Application Ref:	3/2025/0341			 Ribble Valley Borough Council <hr/> www.ribblevalley.gov.uk
Date Inspected:	28/05/2025	Site Notice:	28/05/2025	
Officer:	Kathryn Hughes			
DELEGATED ITEM FILE REPORT:				APPROVAL

Development Description:	Regularisation of unauthorised removal of first floor front timber bay window and replacement with upvc window and metal balustrade.
Site Address/Location:	Tillotsons Arms, 18 Talbot Street, Chipping, PR3 2QE

IMAGES of new first floor window

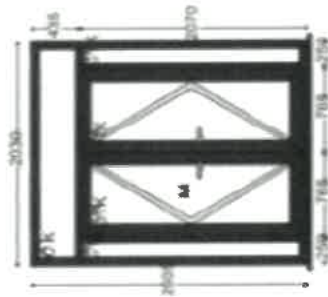
Having regard to the design/appearance and materials of the inserted new window/doors and metal railings, the window size is at odds with the adjacent first floor window and the insertion of the curved metal railings draws some attention to the feature. UPVC is not usually considered an appropriate material within the Conservation Area and it is therefore considered that its size, design and material has resulted in a low level of less than substantial harm to the Chipping Conservation Area, however when weighed against the public benefit of the removal of the unsafe bay window which was not a historical feature nor was it noted as contributing positively to the Conservation Area, the level of harm is considered to be no more than the pre-existing level. In addition, the darker colour windows are considered to draw less attention of the building and feature, which is considered to help reduce its visual impact within the street scene and improve upon the setting of the adjacent listed buildings.

Observations/Consideration of Matters Raised/Conclusion:	
<p>The retention of the existing door/window and railings are considered to result in a low level of less than substantial harm to the Chipping Conservation Area, however it is considered that on balance, the level of harm is no greater than pre-existing level resulting from the timber bay window. In addition, concerns were raised regarding the safety of the window and as such, its retention is considered to be acceptable and would have a neutral impact on the character of the street scene and the Forest of Bowland National Landscape. The harm identified to the Conservation Area is considered to be outweighed by the benefits identified above and the proposal accords with Key Statement EN5 and Policies DMG1 and DME4 of the Ribble Valley Core Strategy and the requirements of Section 16 and 66 of the Planning (Listed Buildings and Conservation Areas) Act 1990 and Section 16 of the National Planning Policy Framework.</p>
